The University of Sydney  
Business School  
Abercrombie Precinct  
Redevelopment

Response to Department of  
Planning's comments

July 2012

Drawing title
GROUND FLOOR PLAN

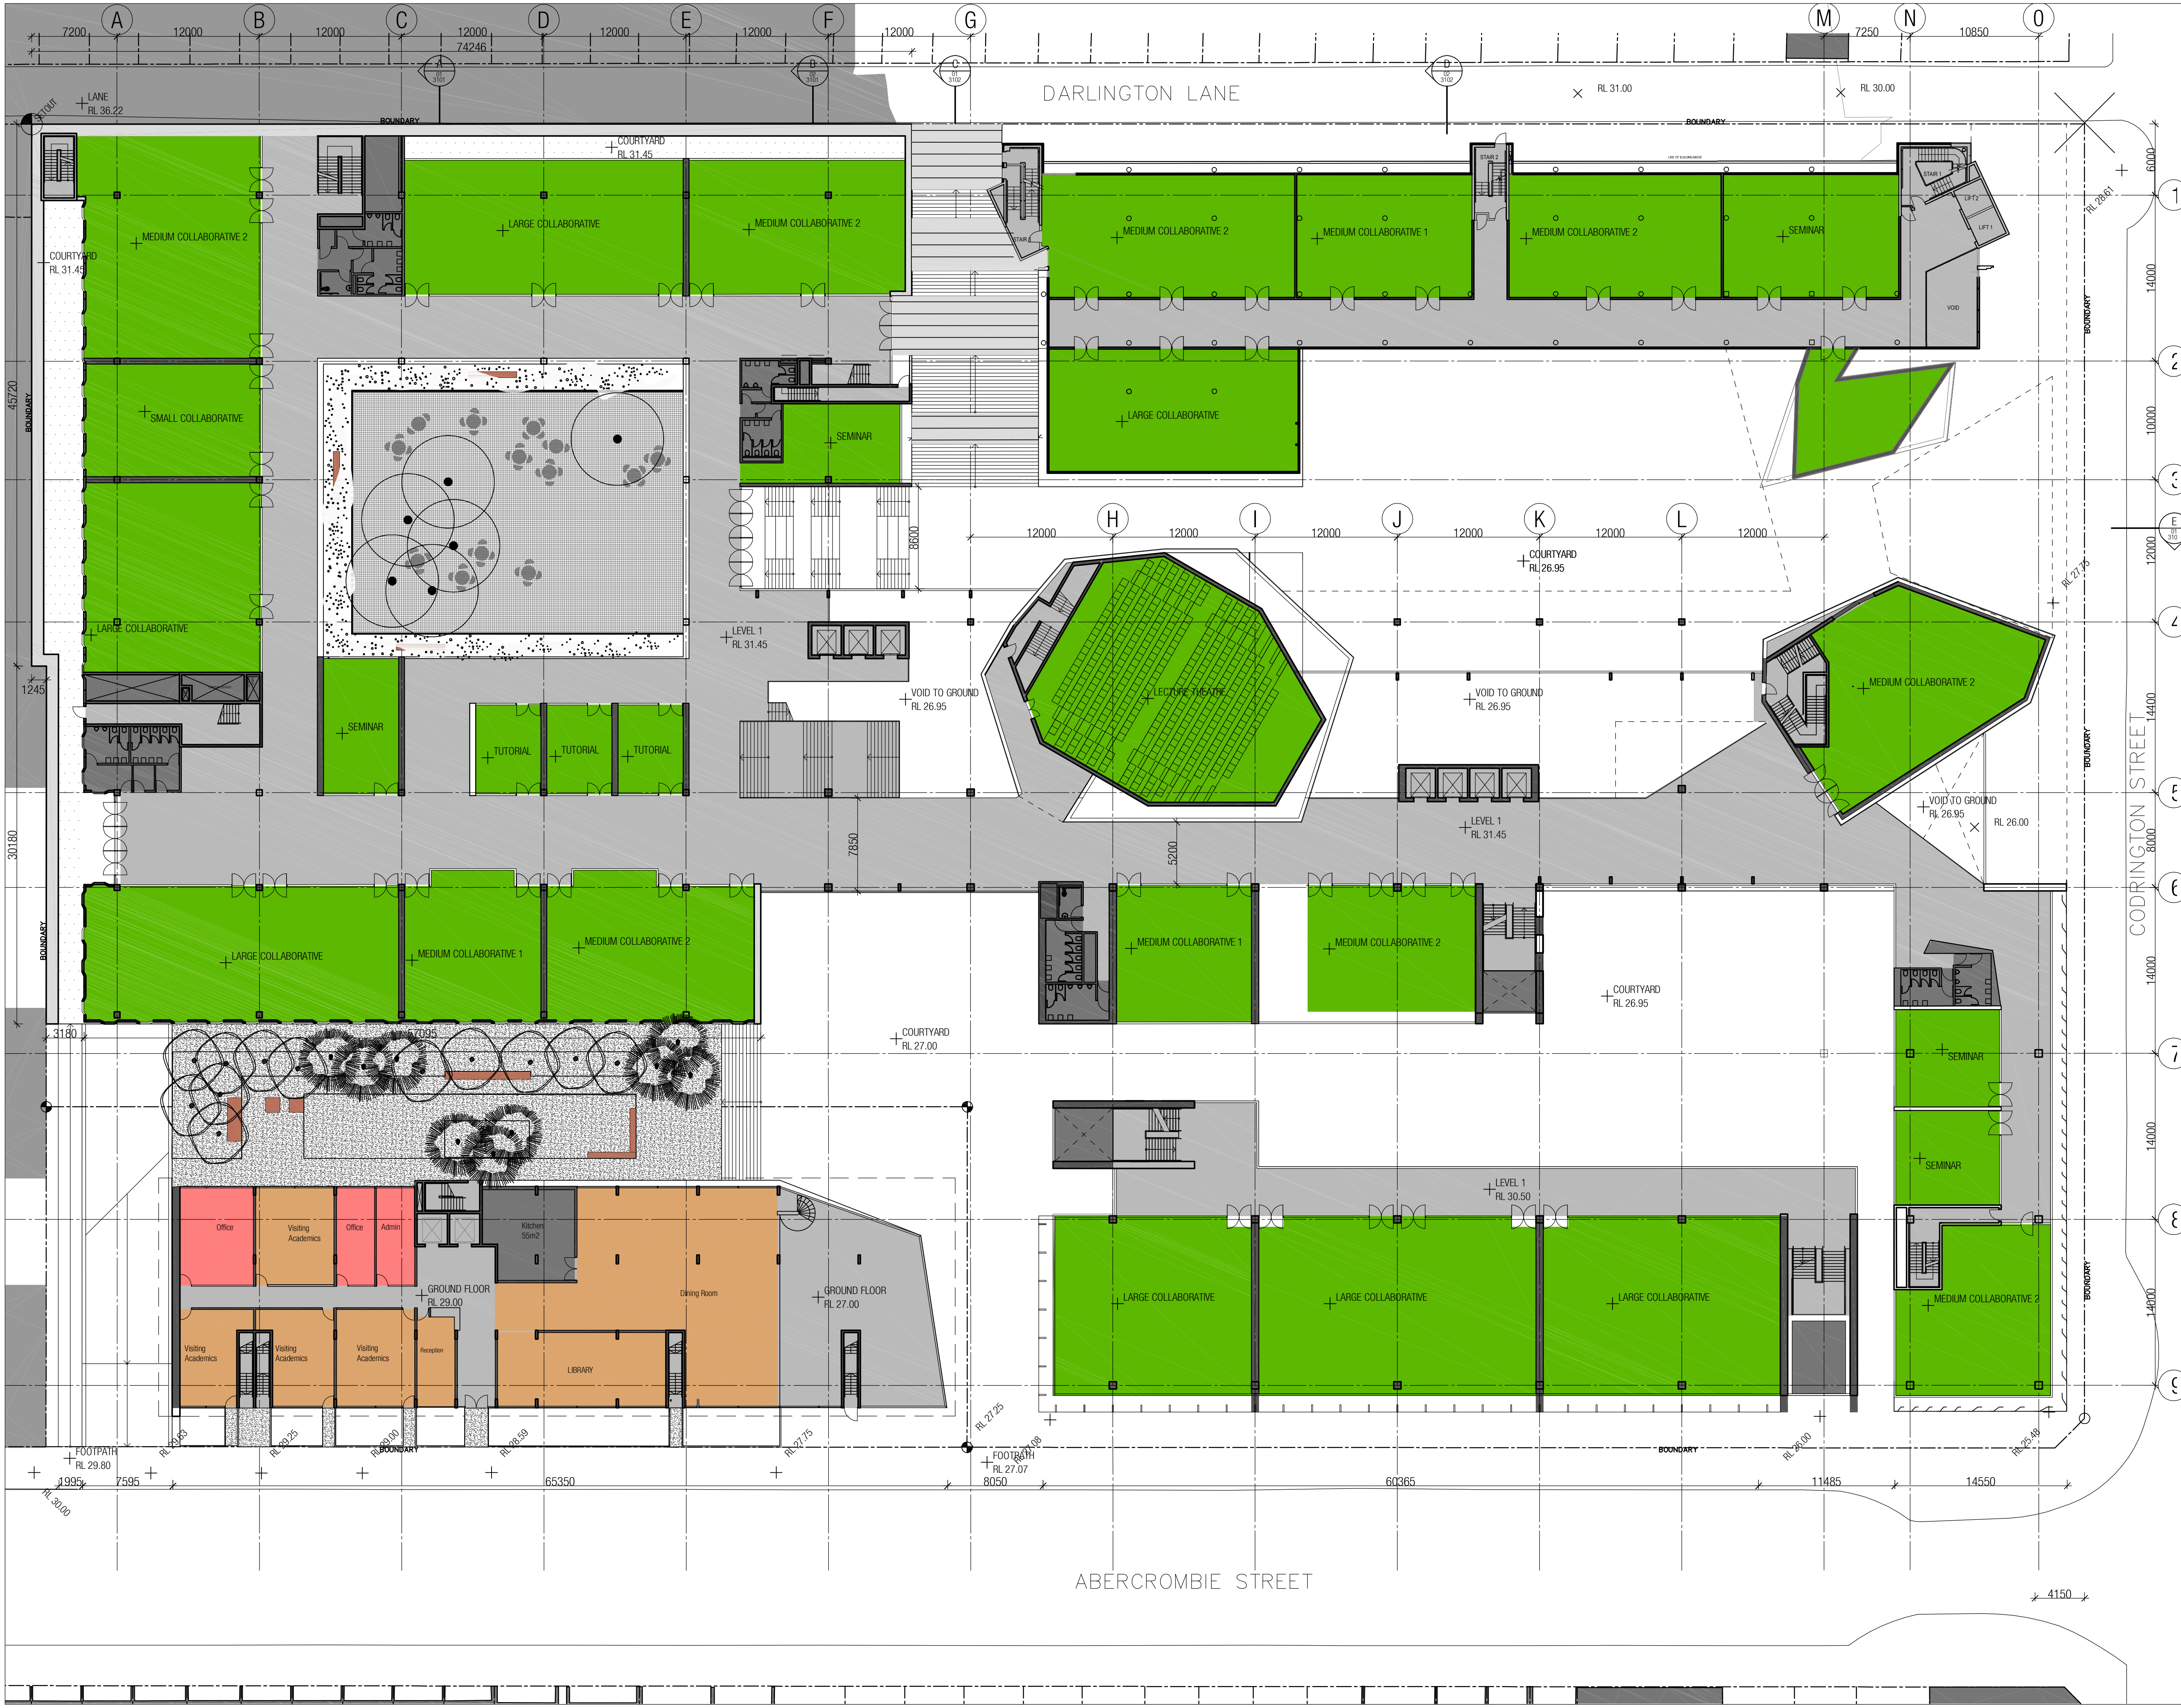
Consideration should be given to increasing the setback of the proposed basement car park vehicle access to a minimum 3.0 m from the existing property boundary of Mandelbaum House. Should the proposed basement car park access be retained in this location on Abercrombie Street, the increased setback will allow for the either retention of the some of the existing Crow Ash trees and/or the establishment of a suitable mature replacement species, which will ensure that the existing green outlook from the existing residential college is maintained.

The vehicle access ramp is now positioned within the student housing building. This allows for a setback of 9.5m from Mandelbaum Façade to the student accommodation building façade. This enables the retention of existing trees and provides a more open pedestrian access route through the site. Furthermore, vehicle noise will be minimised as the ramp is entirely enclosed within the student housing.

Drawing title
**PLAN
LEVEL 4**

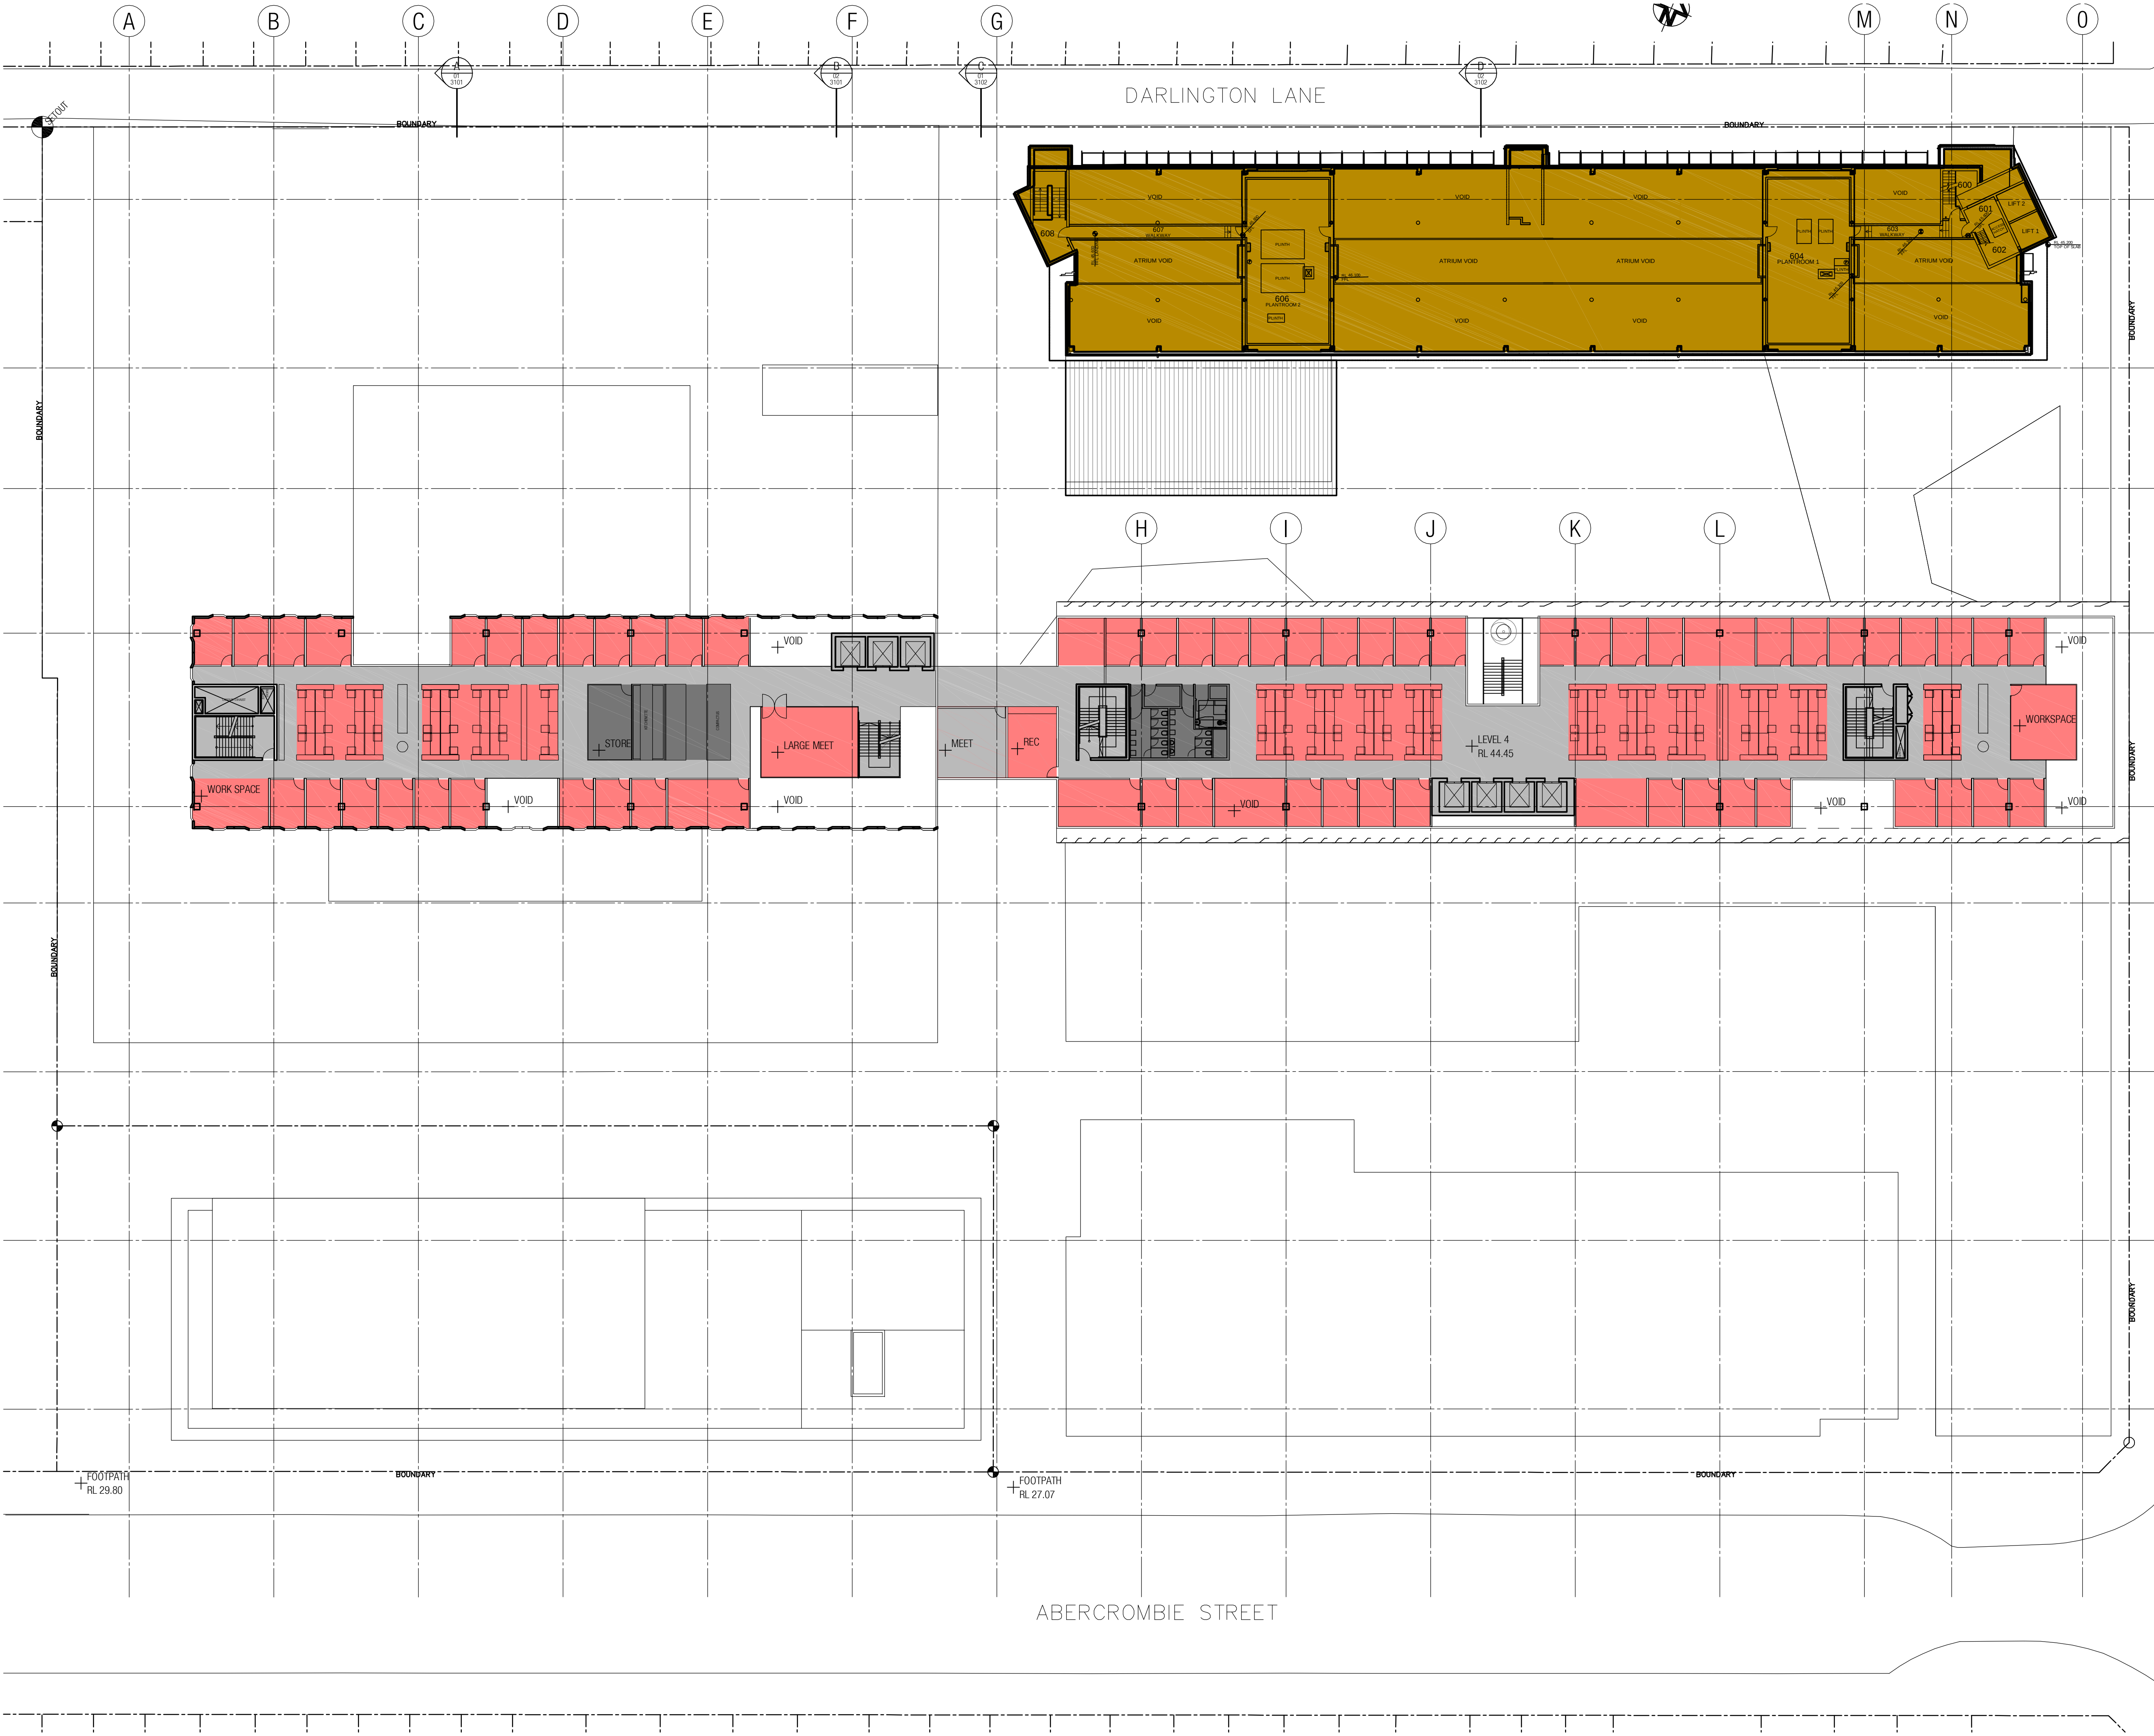
‘The upper level of the business school building, located immediately behind Mandelbaum House, should be setback back to minimise overshadowing impacts on the existing adjacent residential college.’  
and

‘Minimal consideration has been given to the potential impacts of the redevelopment on Mandelbaum House. Greater consideration and justification is required in response to the potential amenity and privacy impacts generated by the proposed development, including the significant overshadowing impacts on Mandelbaum House.’

A terrace has been introduced at level 4 (the uppermost level) of the block nearest Mandelbaum House. The terrace, which creates a 3m setback, is to be treated in the same way as the front building terraces near the Dean’s unit and the dining area where the ceramic baguettes continue as a screen to roof level . This is envisaged to increase daylight penetration when compared to the original Part 3A proposals. Overlooking is minimised through this ceramic baguette screen which can further be angled to both reflect light into the terrace area and create privacy for Mandelbaum House.
